KIRKLEES METROPOLITAN COUNCIL INVESTMENT & REGENERATION SERVICE

DELEGATED DECISION TO DETERMINE PLANNING APPLICATIONS

Reference No:	2021/62/94664/W
Site Address:	Former Hoyle Ing Dyeworks, Hoyle Ing, Linthwaite, Huddersfield, HD7 5QS
Description:	Demolition of existing building and development of the former Dyeworks comprising 9 apartments, 4 bungalows and 2 maisonettes (within a Conservation Area)
Recommending Officer:	Ellie Worth

| DATE: 07-06-21 | SCALE @ A1 1:100 | DRWG: HA-MRLW-010 REV.B

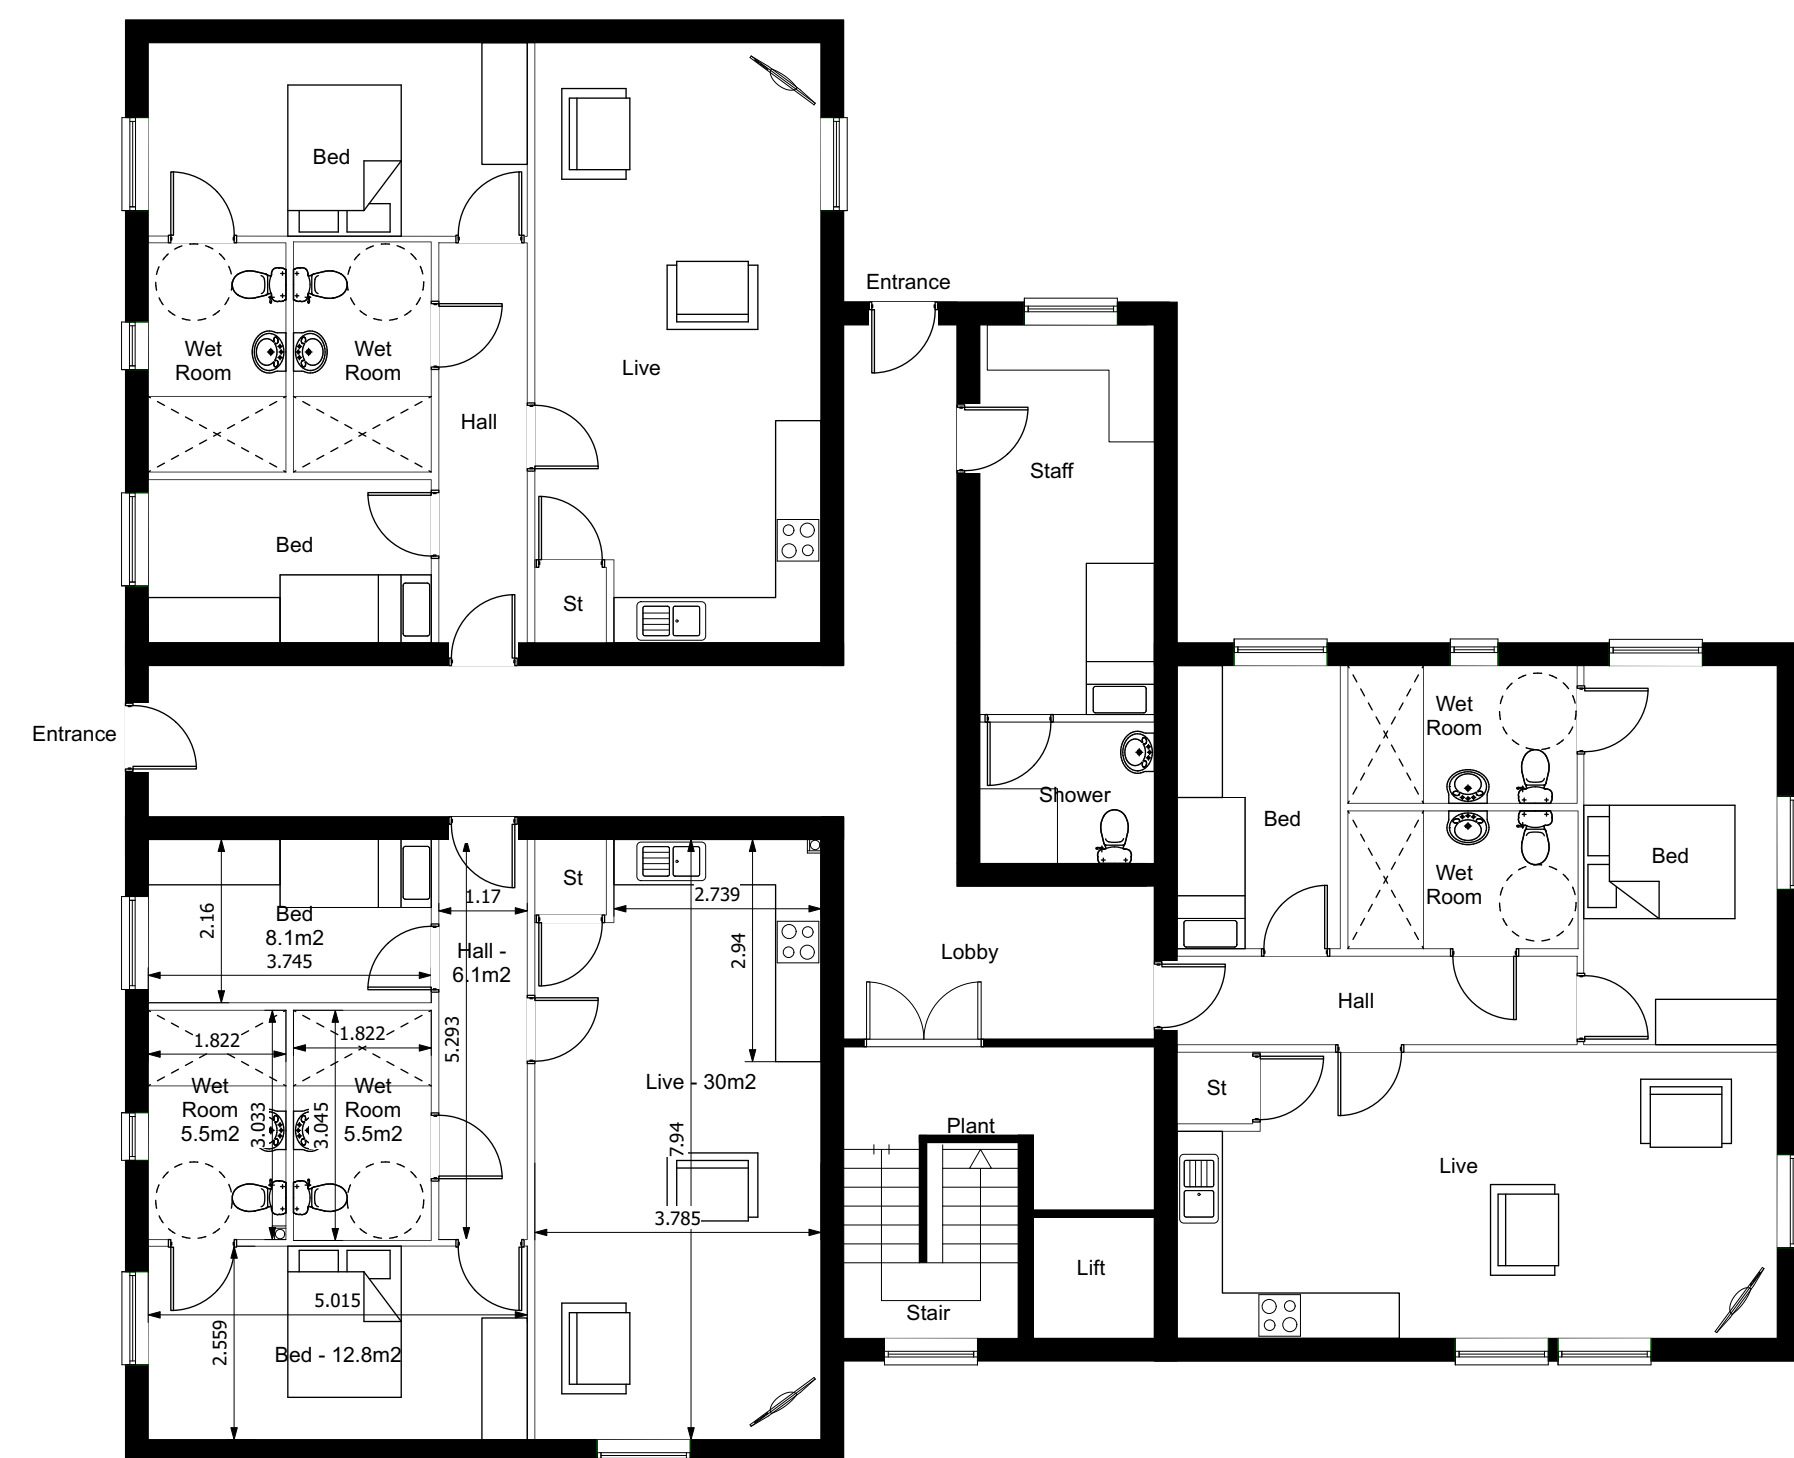
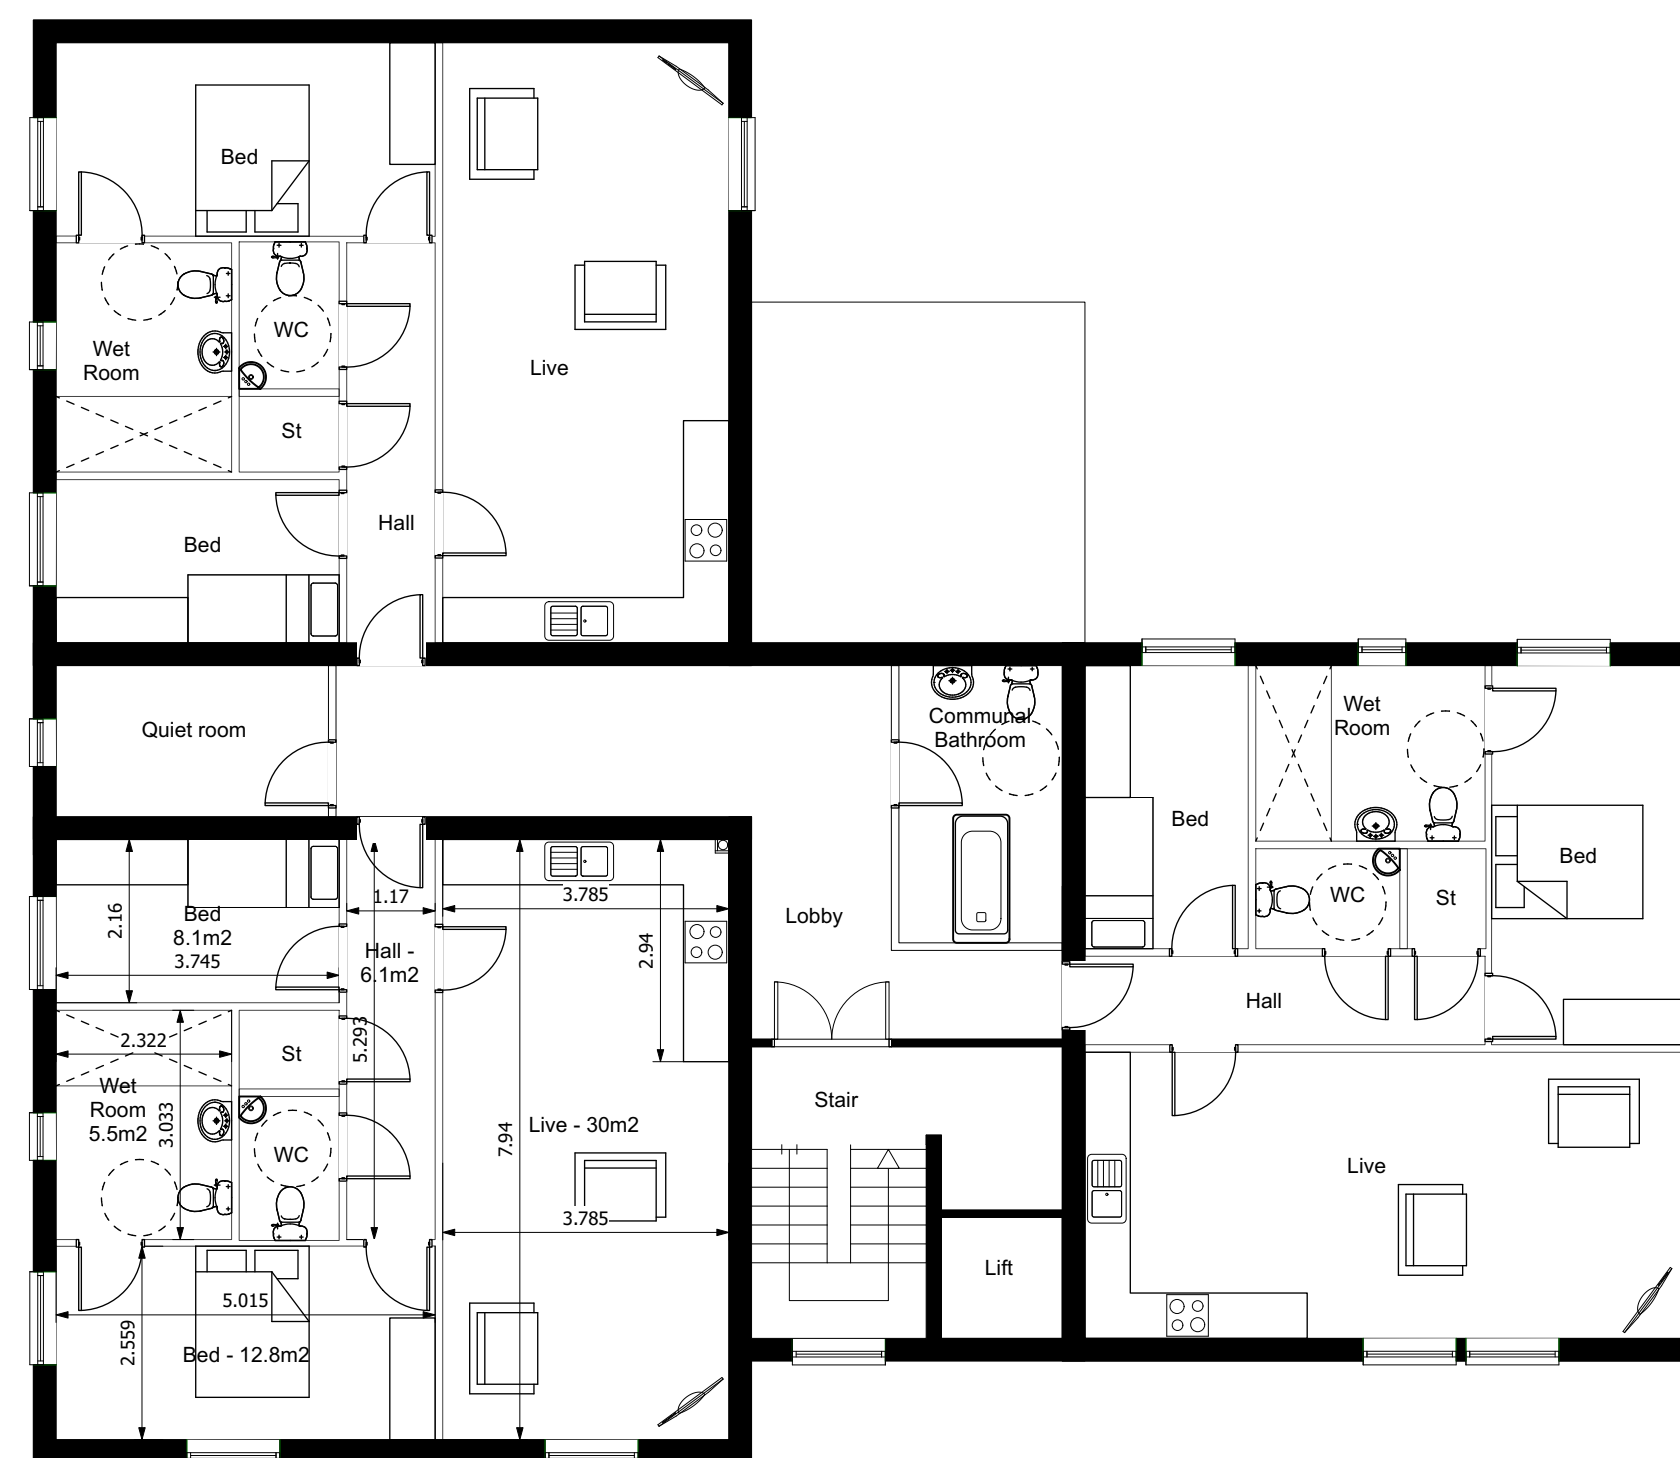
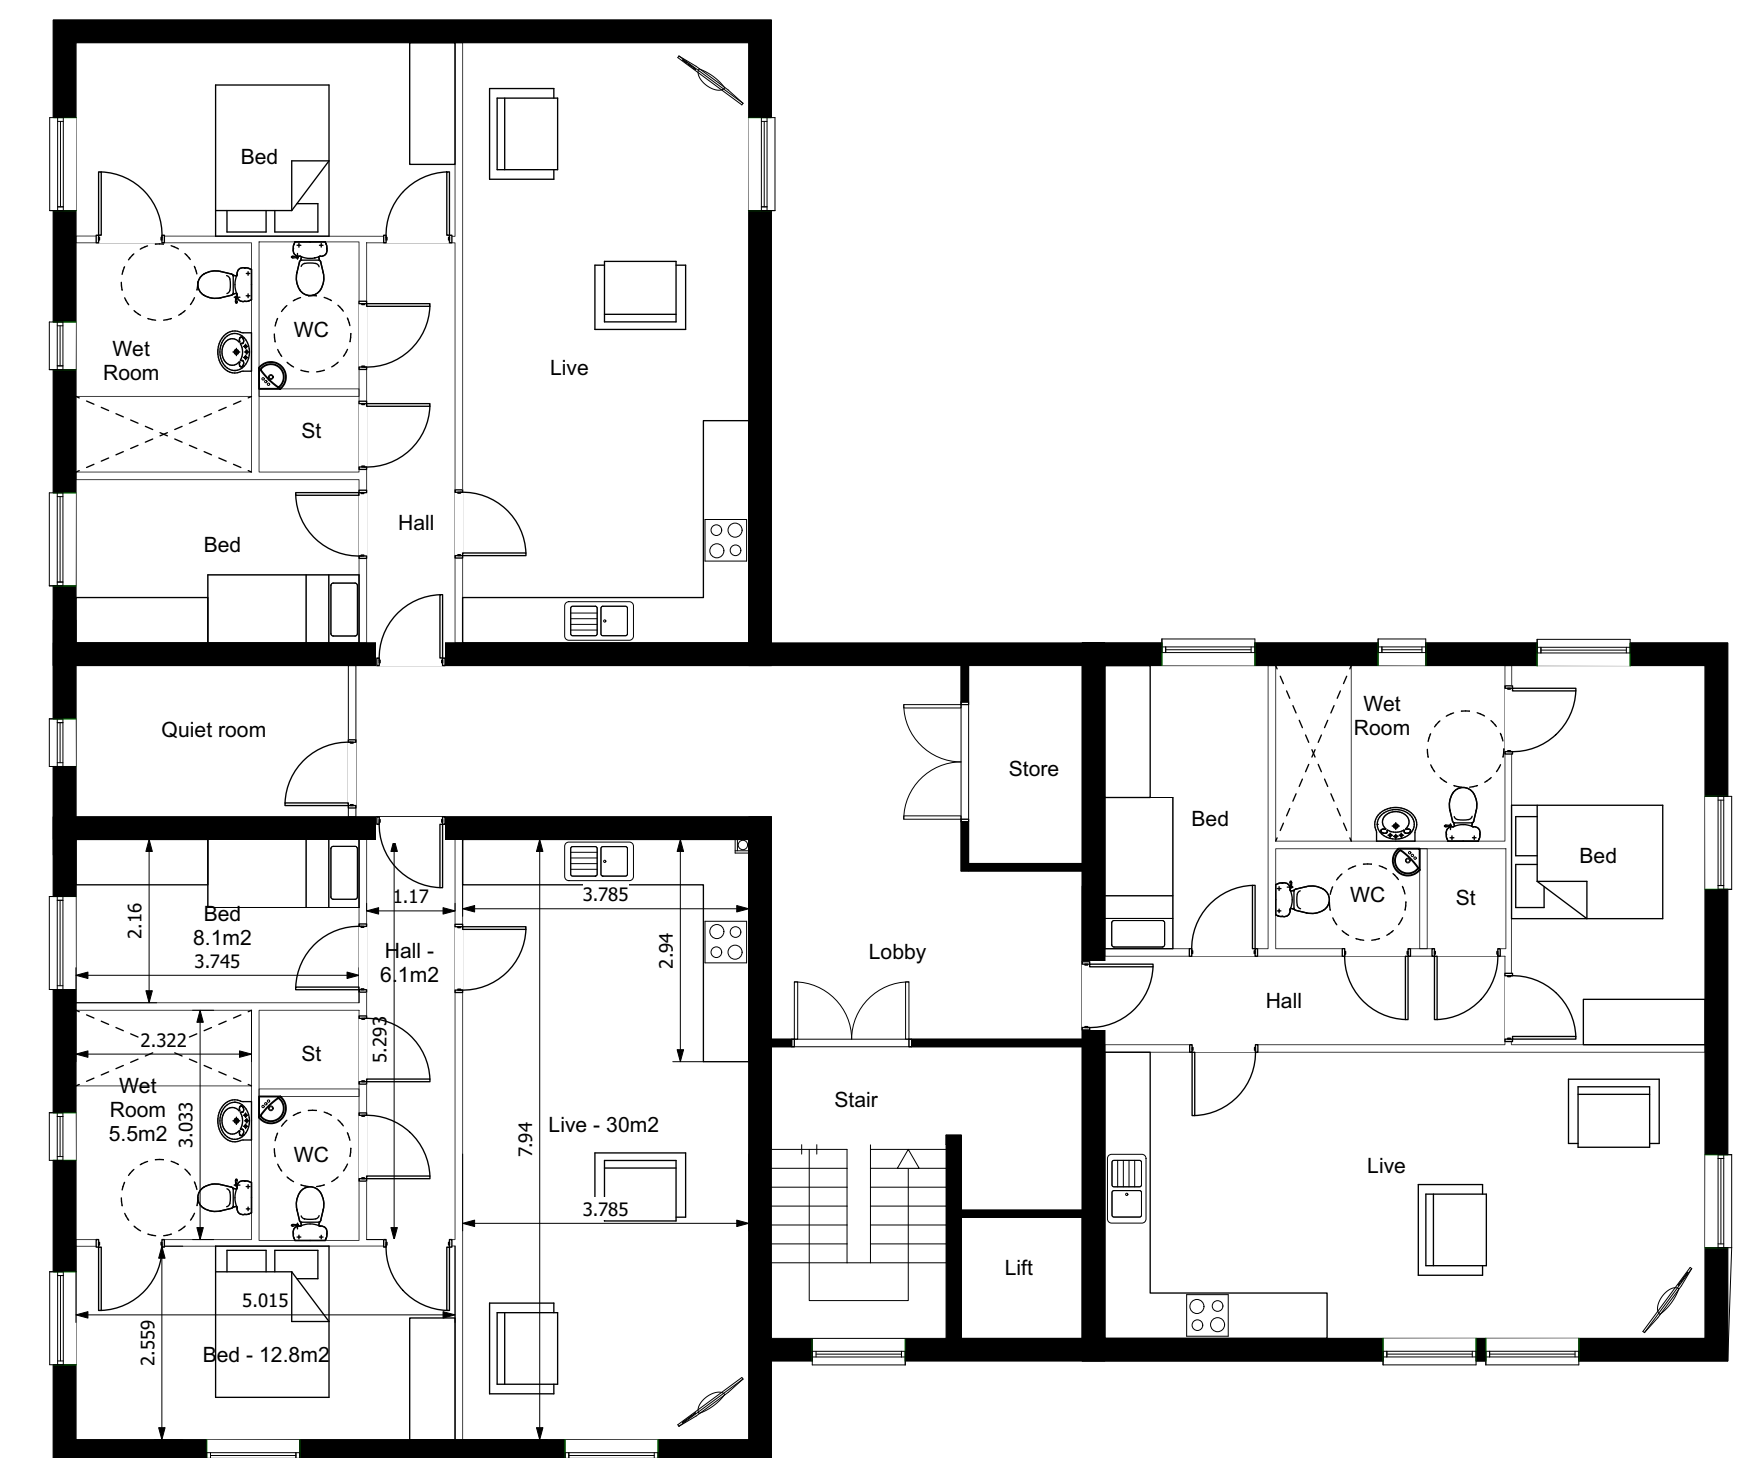
In drawing HA-MRLW-010 the applicant proposed the reuse of some of the stone features of the Manchester Road elevation of the 1906 office/warehouse building. However, this re-use was no longer shown in rev B of that drawing. These stone features (including a 1906 date stone, lintels, surrounds, cornices, voussoirs, corbels, copings and kneelers) must be reused in any development at this site, to reflect the history of the site, to reference the building that is to be demolished, and to assist in making the proposed demolition acceptable. A condition is recommended, securing drawings (showing where and how the features would be reused) and implementation of the necessary reuse.

Some of the elevations on drawing HA-MRLW-010 rev B include continuous horizontal elements at lintel level. These are considered inappropriate, as they would undermine the vertical emphasis of the building's fenestration. An amending condition is recommended.
